SICEEP Public Private Partnership DA SSD 13_5752

Submission to NSW Department of Planning and Infrastructure
22 May 2013

CITY OF SYDNEY 
city of villages

22 May 2013

<b>DRAWING TITLE</b> EVENT DECK CANOPY AXONOMETRIC				
<b>STATUS</b> DEVELOPMENT APPLICATION				
SCALE @ A1 / 50% @ A3 1 : 1500	DRAWN NT	CO-ORD NT	REVIEWED NT	APPROVED GS
PROJECT NUMBER AX003688	DRAWING NUMBER EX_AR_2003		REV A

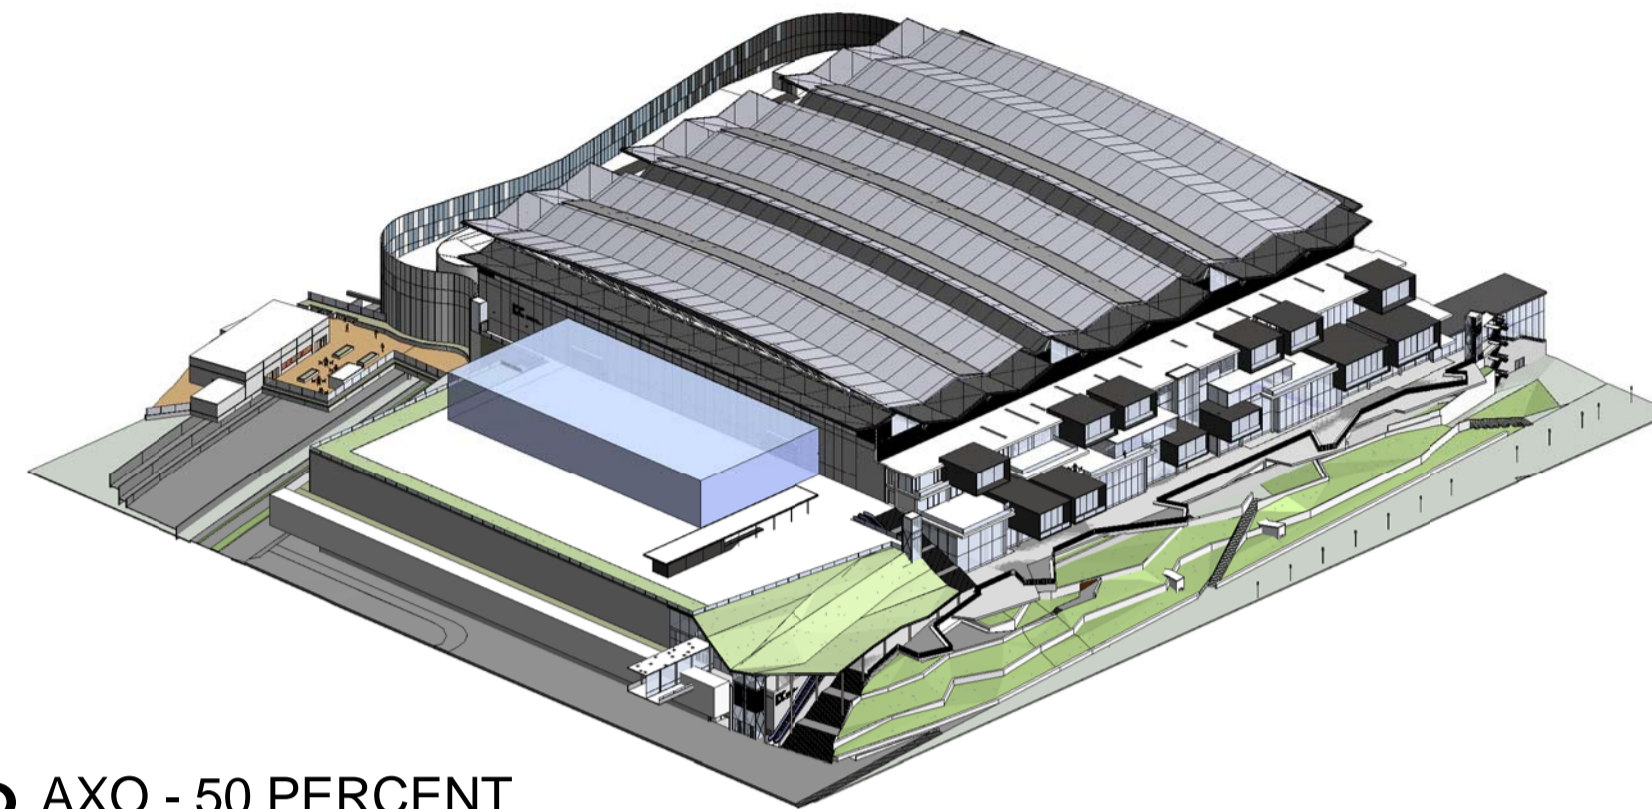
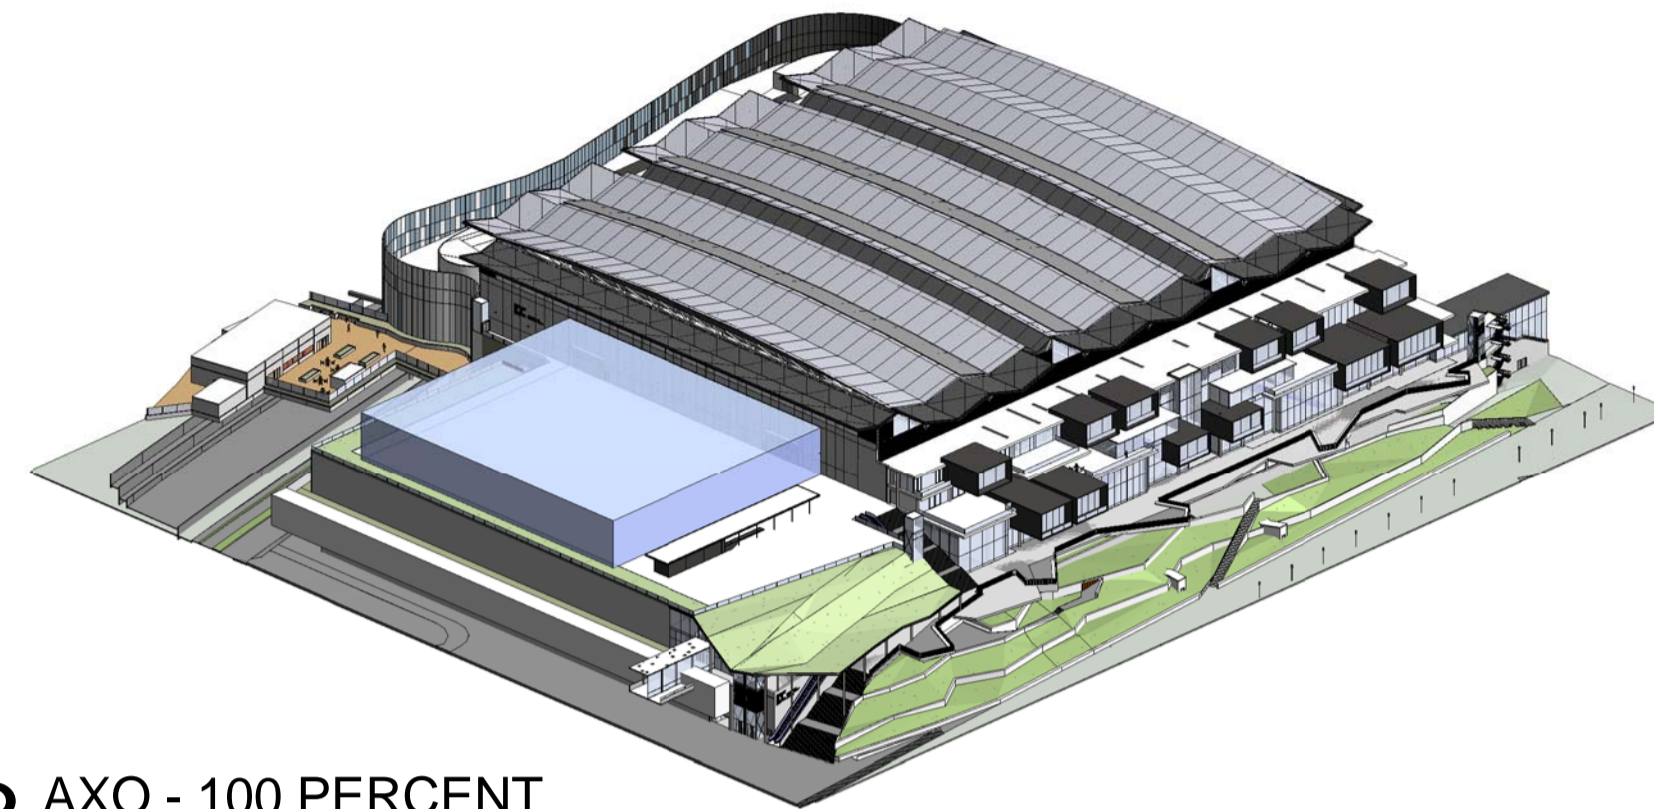
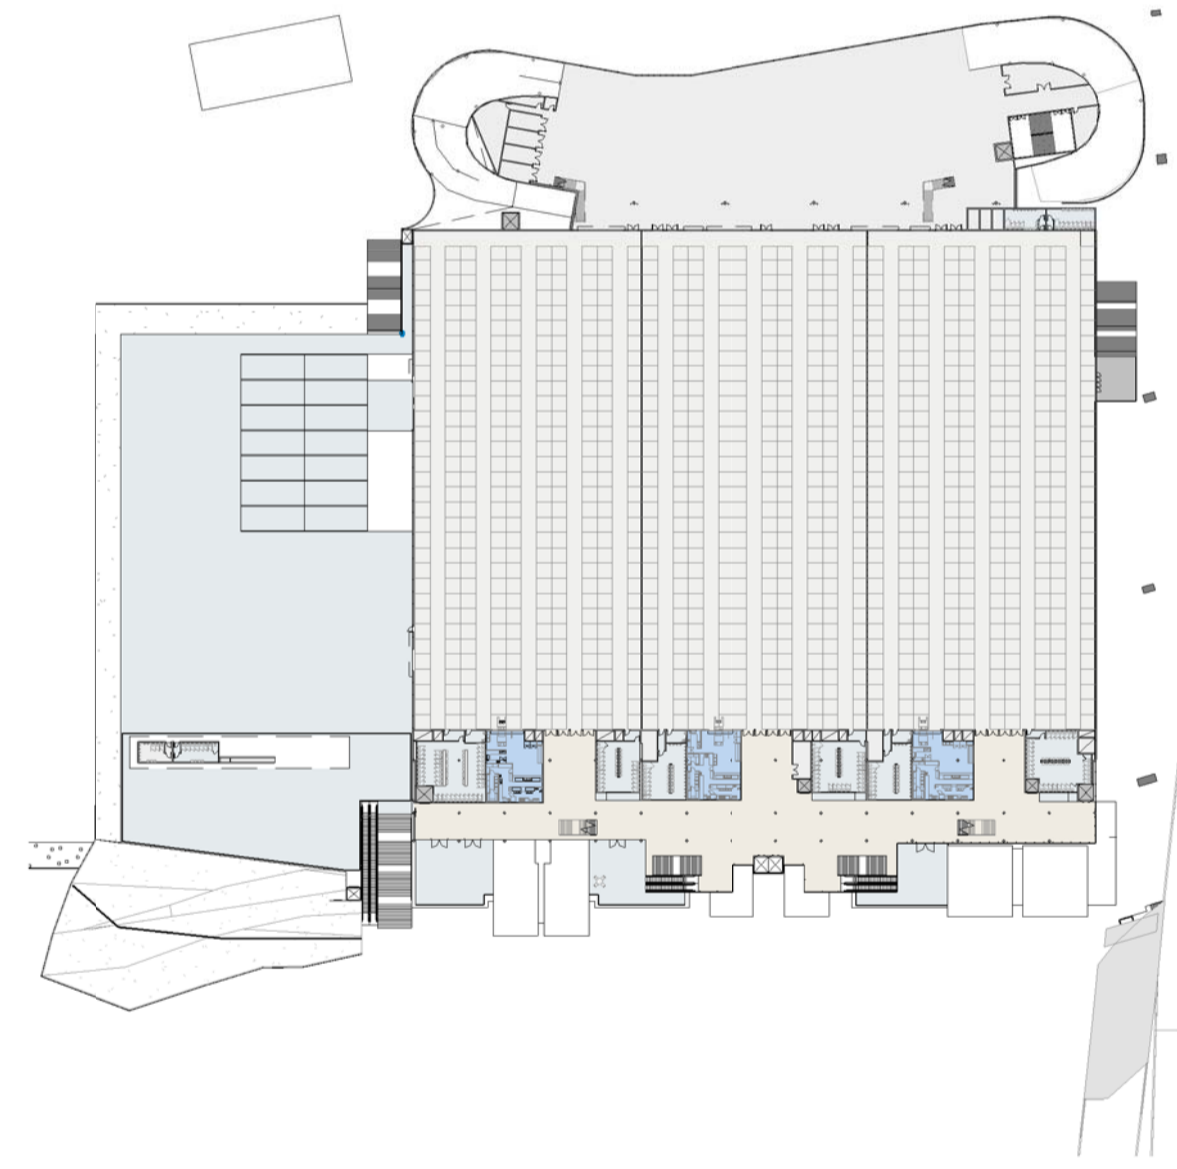
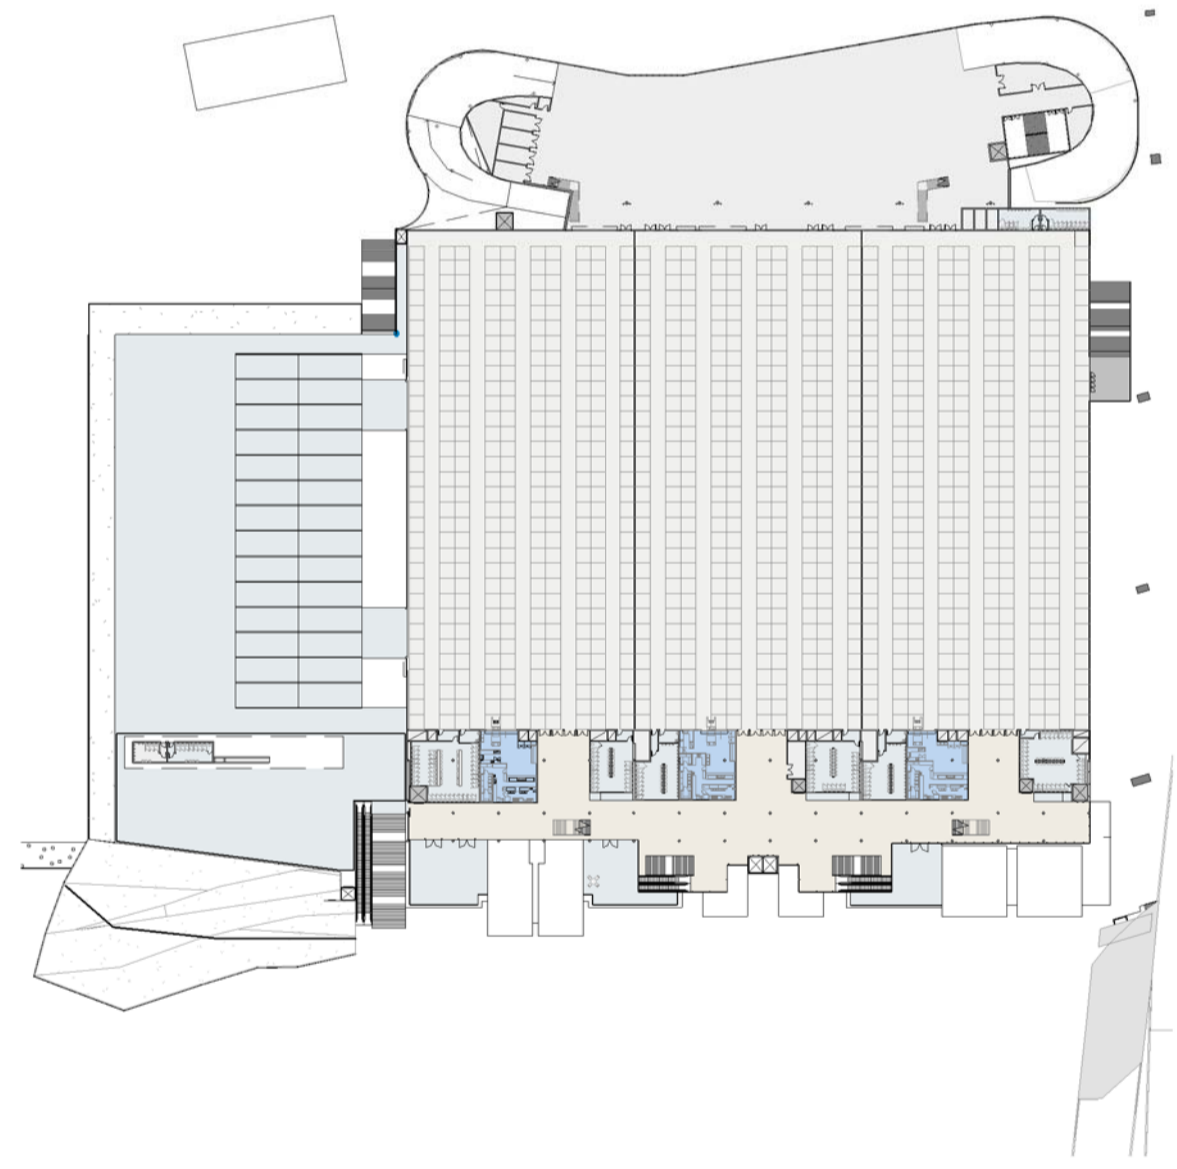
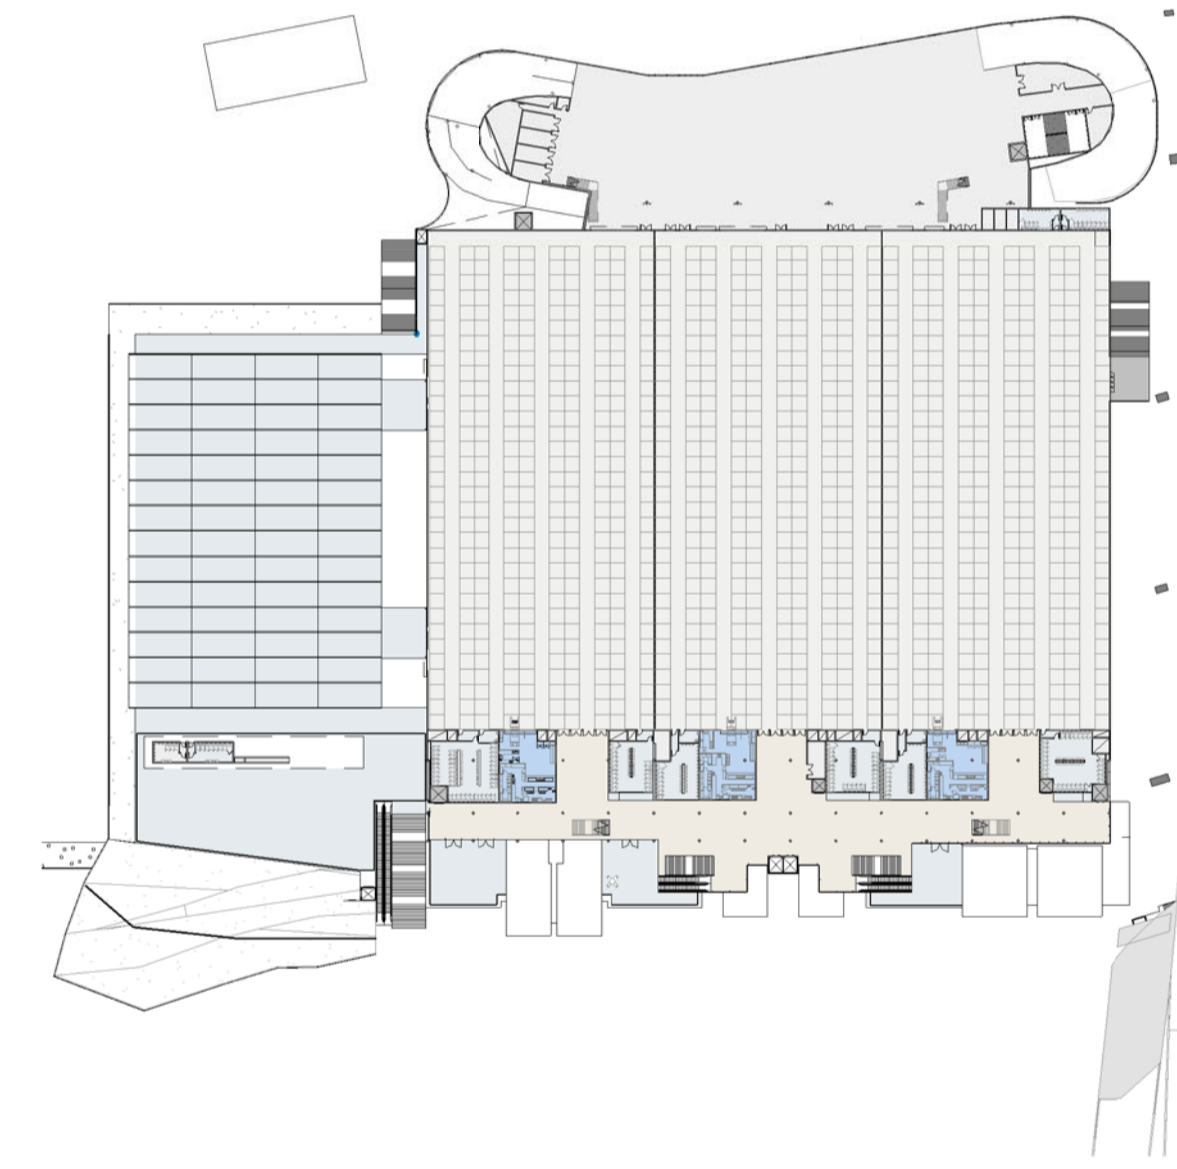
When events are underway on the Event Deck, the concept of direct access to Quarry Street may be lost due to temporary marquees, tents, canopies and restricted access. The Event Deck should remain an open deck in perpetuity

rather than covered by any permanent or even temporary awnings or structures. It is essential that greater priority and design emphasis is given to a ground level pedestrian connection from Pyrmont and Ultimo to the site crossing the light rail at a station location.

The design intention to have a green landscaped edge along the Event Deck will not be readily legible from the public domain to the canopy's elevation. The green edge may be costly, difficult to maintain and add little value to the proposal.
